Item No. **Report of the Head of Planning, Transportation and Regeneration**

Address SILVER BIRCHES TILE KILN LANE HAREFIELD

Development: Part two storey, part single storey side extension, single storey rear extension and conversion of roof space to habitable use to include 2 x front and 6 x rear roof lights involving demolition of existing garage

LBH Ref Nos: **75438/APP/2020/727**

PROPOSED GROUND FLOOR PLAN - 1:100

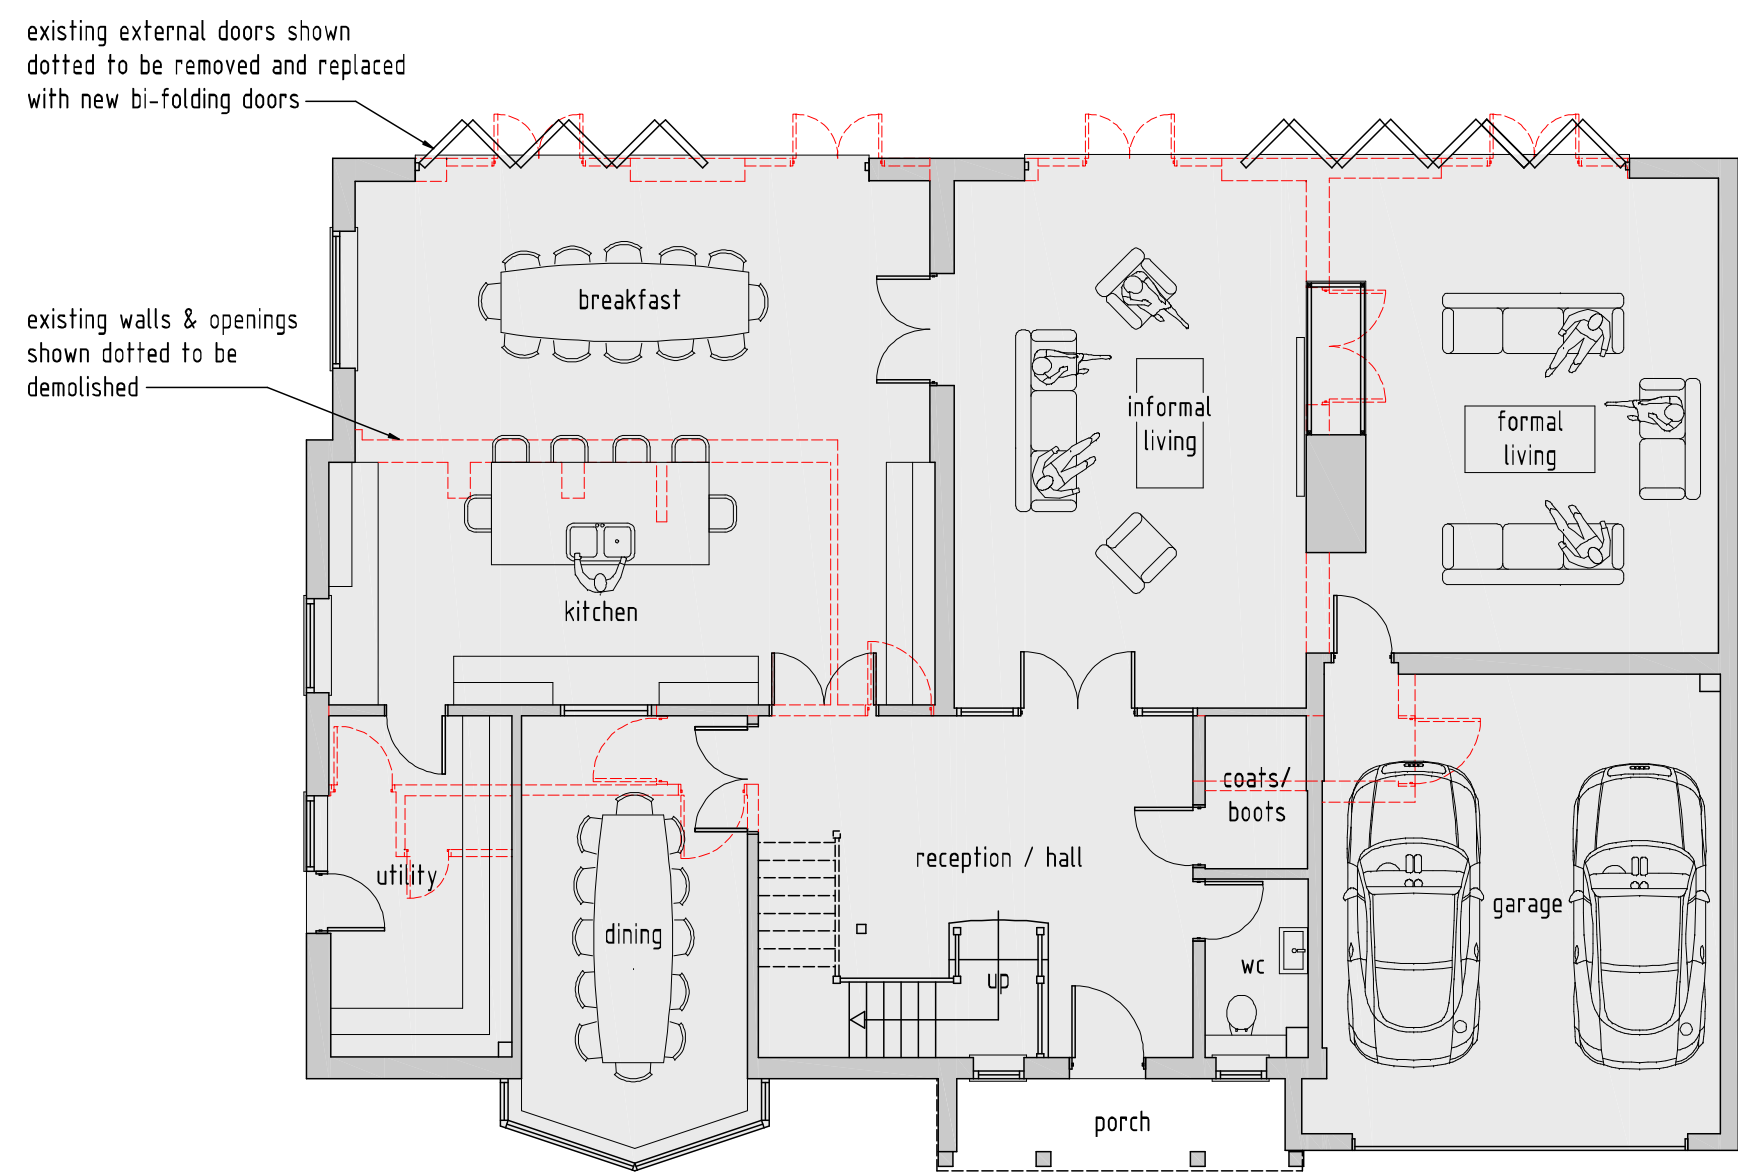
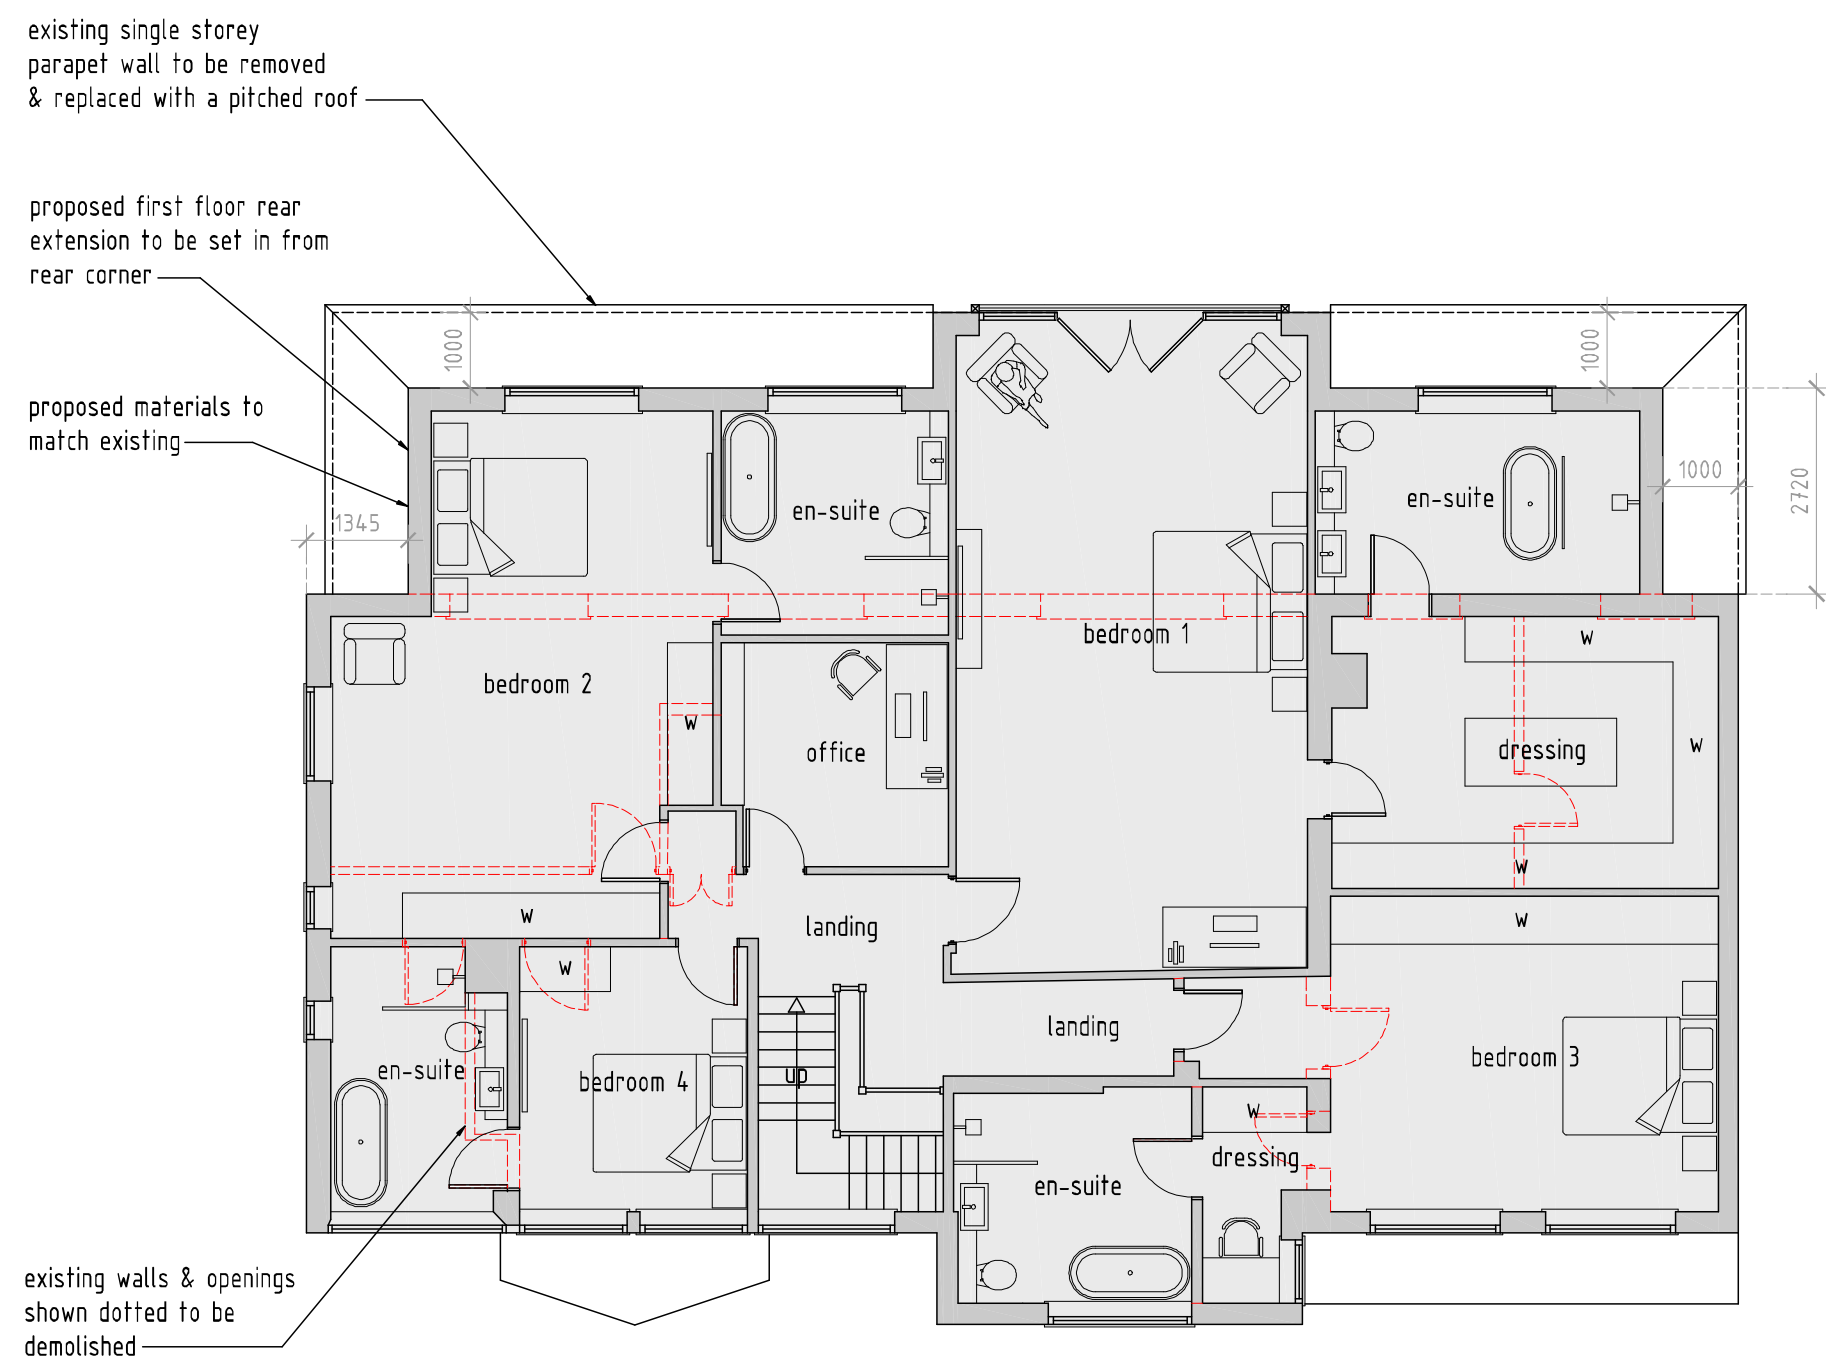
Whilst it is noted that the side extensions sit largely on the footprint of the existing linked garage, this is a substantial addition to the original property. The proposed side extension measures 10.4m in width in comparison to the 11m width of the original dwelling, increasing the height and extending forward of the main front building line. The floor area of the original dwelling and garage was approximately 230sqm. The proposed extension would result in a dwelling with a floor area of approximately 481sqm, over double the size (an increase of 109%). The proposal would therefore fail to appear subordinate to the existing property and would be a disproportionate addition over and above the size of the original building. As such, the development fails to comply with the requirements of Policies BE1 and EM2 of the Hillingdon Local Plan: Part One - Strategic Policies (November 2012), Policies DME1 4, DMHB 11 and DMHD 1 of the Hillingdon Local Plan: Part Two - Development Management Policies (2020), Policy 7.16 of the London Plan (2016) and the NPPF..

The proposed two storey side/front extension and single storey side extension, by virtue of its size, scale, bulk and width, including the lack of set back from the front elevation, would fail to appear as subordinate additions and would thus, fail to harmonise with the architectural composition of the original dwelling. As such they would be detrimental to the character, appearance and visual amenities of the street scene and the surrounding area. Therefore the proposal would be contrary to Policy BE1 of the Hillingdon Local Plan: Part One - Strategic Policies (November 2012) and Policies DMHB 11 and DMHD 1 of the Hillingdon Local Plan: Part Two - Development Management Policies.

PROPOSED REAR ELEVATION - 1:100

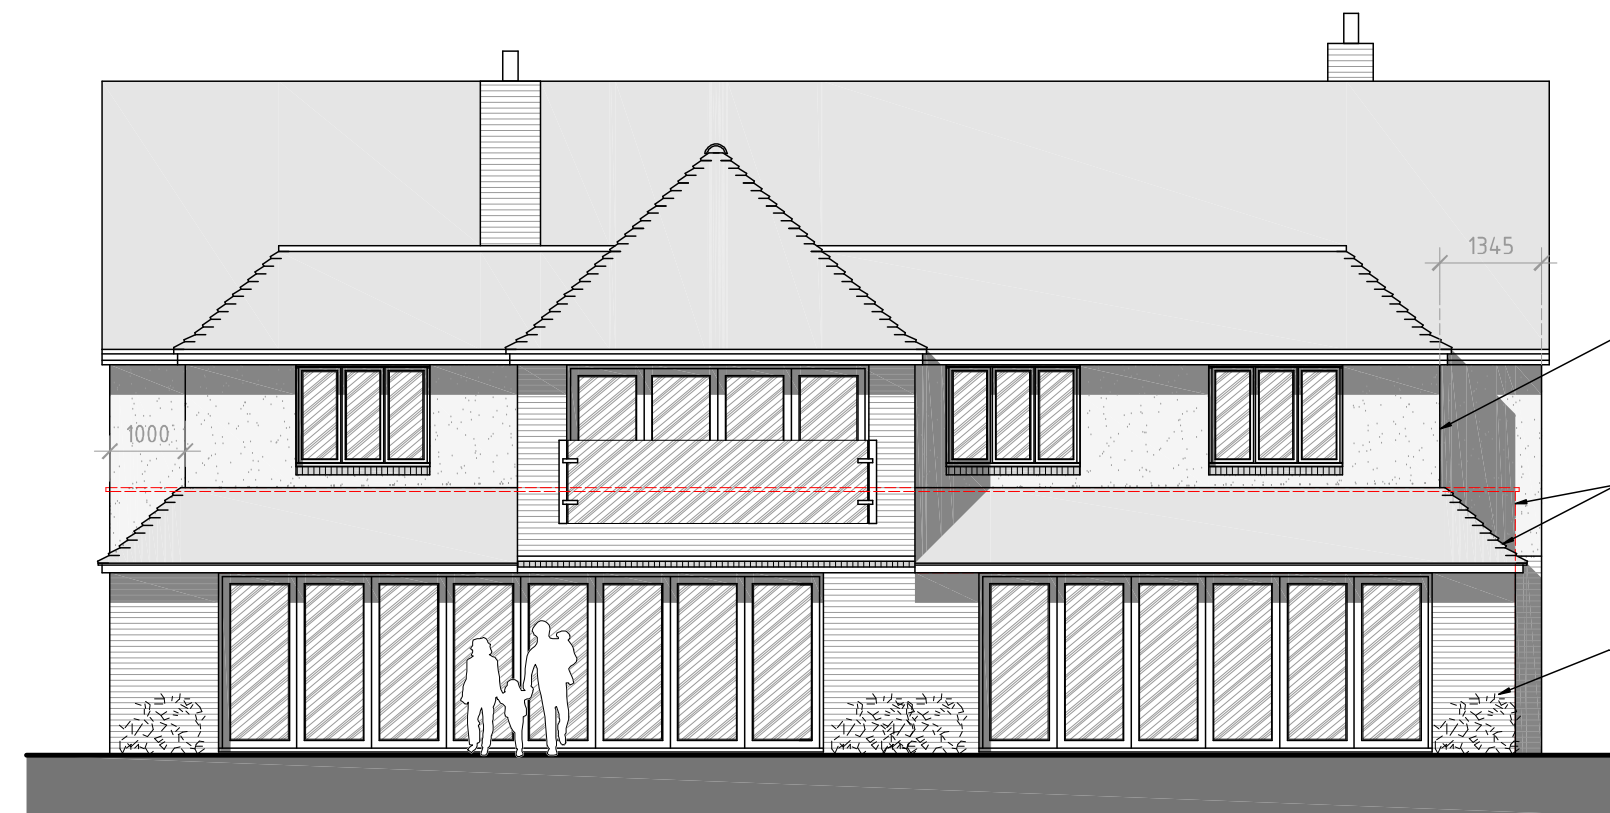
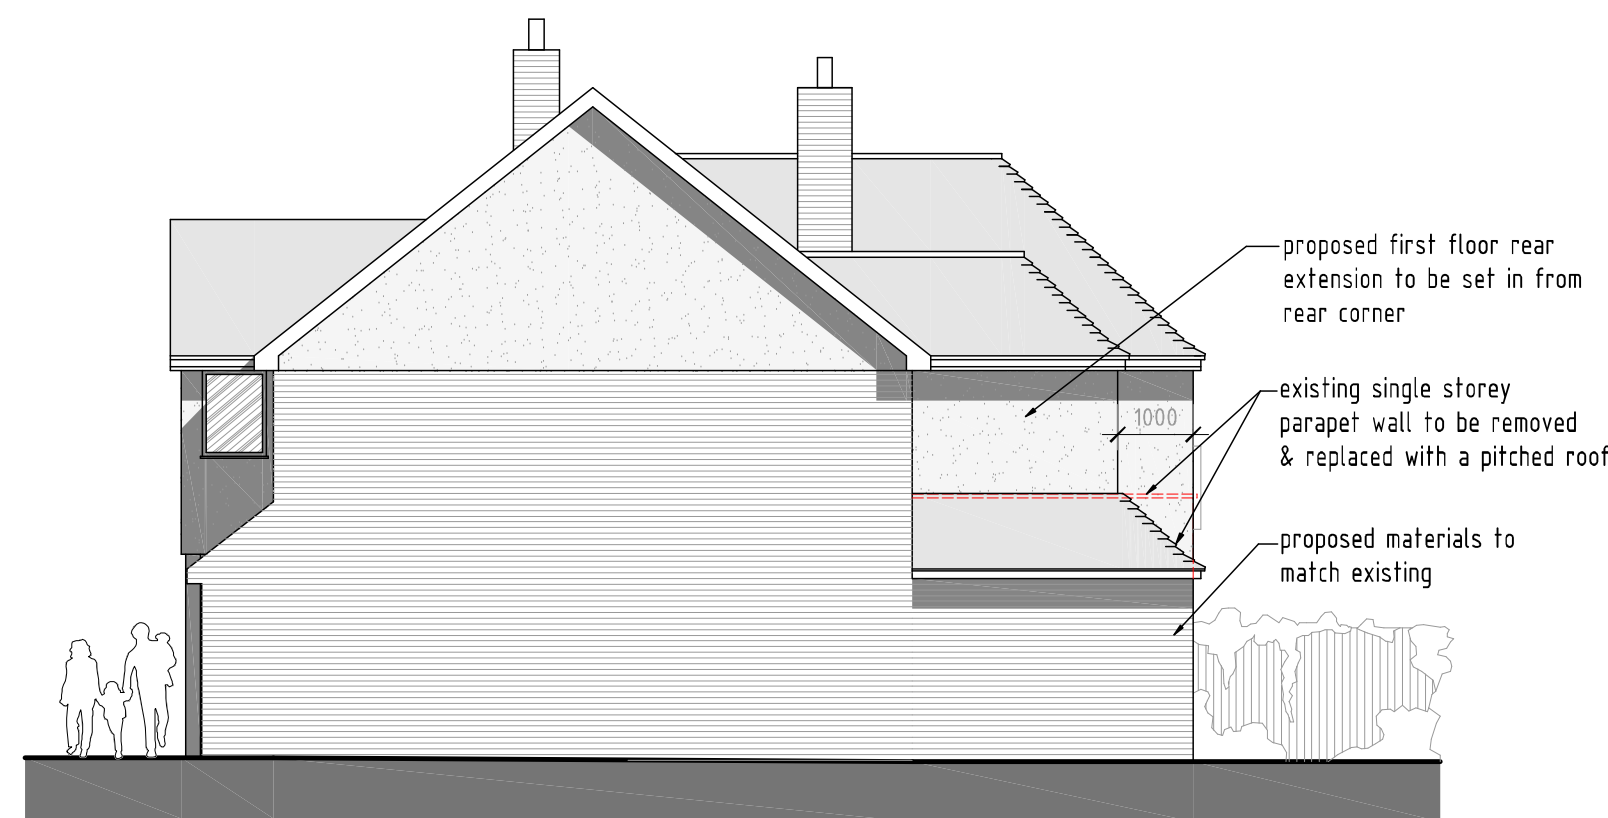
The proposed extension by reason of its size, scale, bulk, height and width, would represent a disproportionate change in the bulk and character of the original building and therefore would significantly increase the built up appearance of the site and would be visually intrusive within the street scene and the wider area. The proposal would therefore constitute inappropriate development in the Green Belt, contrary to Policies
